Application Reference Number:	2025/0323		
Application Type:	Listed Building Consent		
Proposal Description:	Removal and replacement of one rotting window in the northern elevation (Listed Building Consent)		
Location:	Rosebower, Caulk Lane, Swaithe, Barnsley, S70 3QG		
Applicant:	Mr Andrew Lennighan		
Third-party representations:	None	Parish:	
		Ward:	Worsbrough

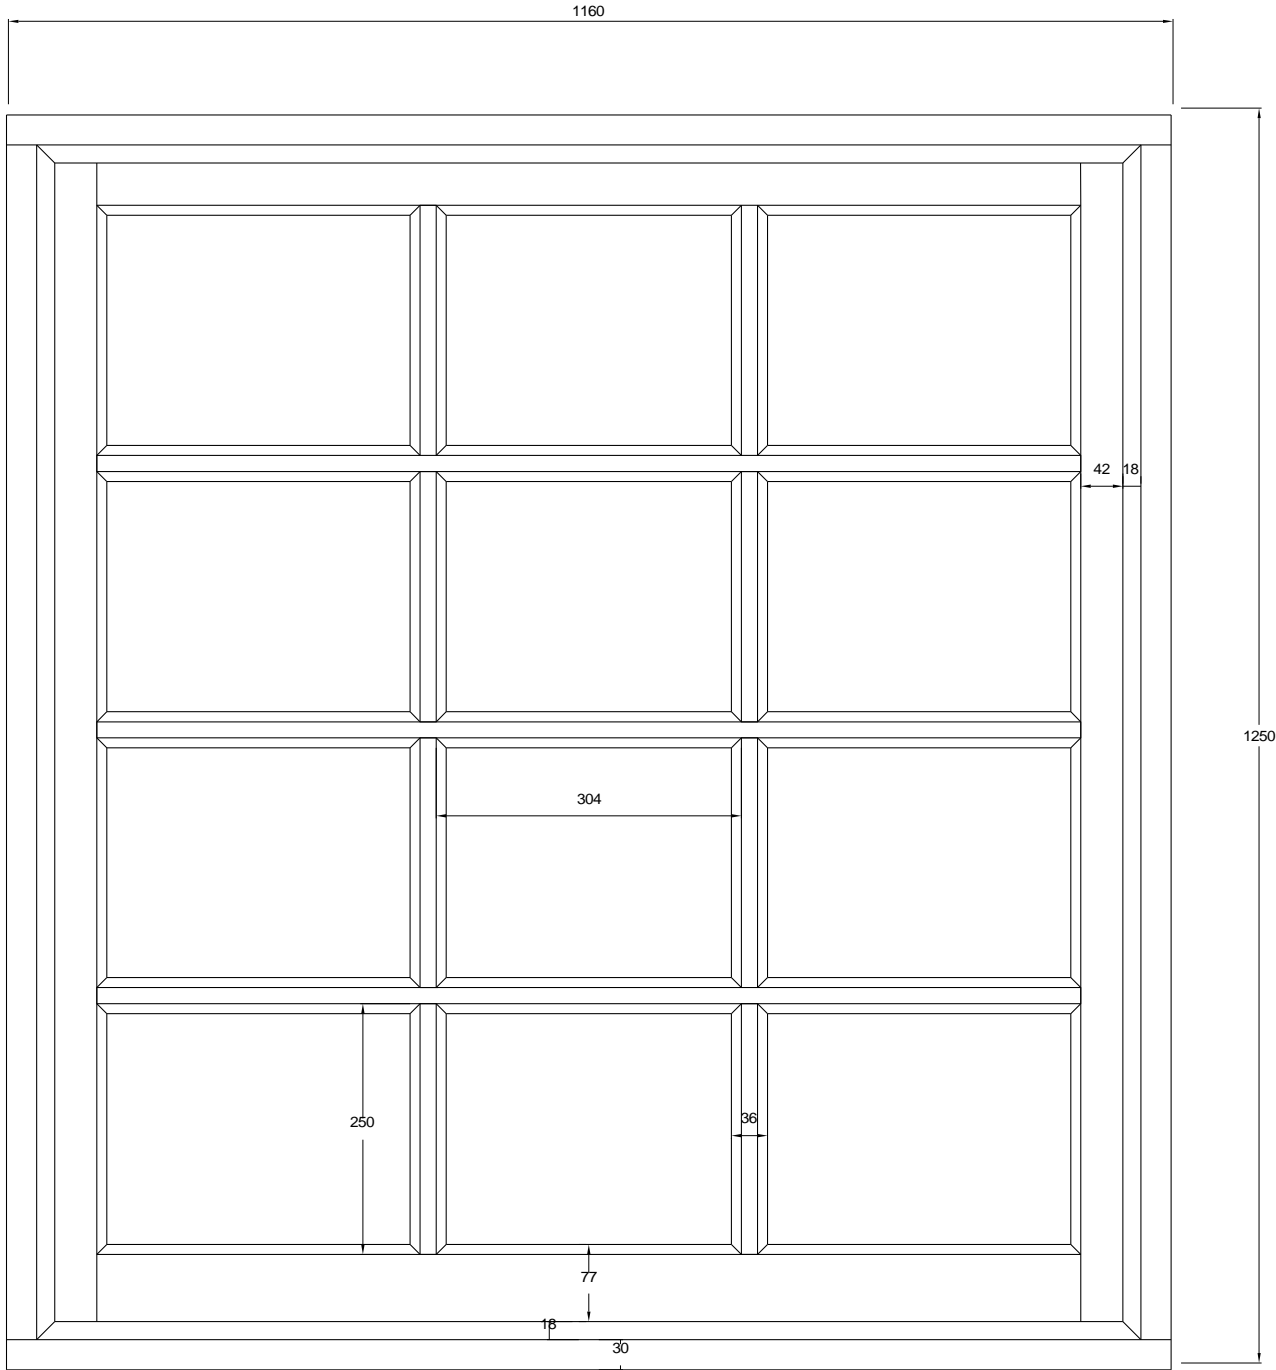
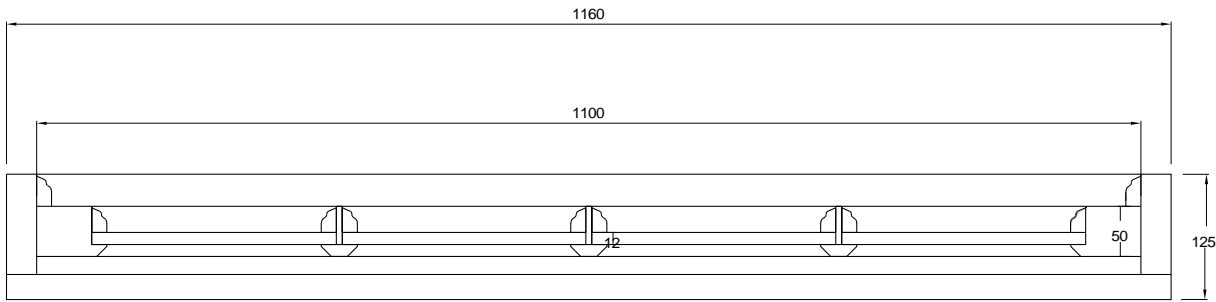
This application seeks Listed Building Consent for the replacement of a single north facing side sliding Yorkshire Sash, to Rosebower, which is part of the grade II Swaithe Hall. The existing window to be replaced is not original, but a C20 replacement of recent age (circa 2000). Yorkshire Sliding Sash are generally not typical in the borough, primarily due to issues with weather sealing and general protection from the elements. This would have been particularly important in more upland areas, or exposed locations (which there are many of in Barnsley and the wider Pennine fringe).

The proposal details a single fixed window in hardwood decorated to match. However, the window would change from a side by side sliding sash (8x8 square lights) to a fixed 12 light timber window. Given the modern fabric of the existing window, the slight visual change, and the high quality of design and materials it is deemed that the proposal will not harm the listed building. This weighs significantly in favour of the proposal.
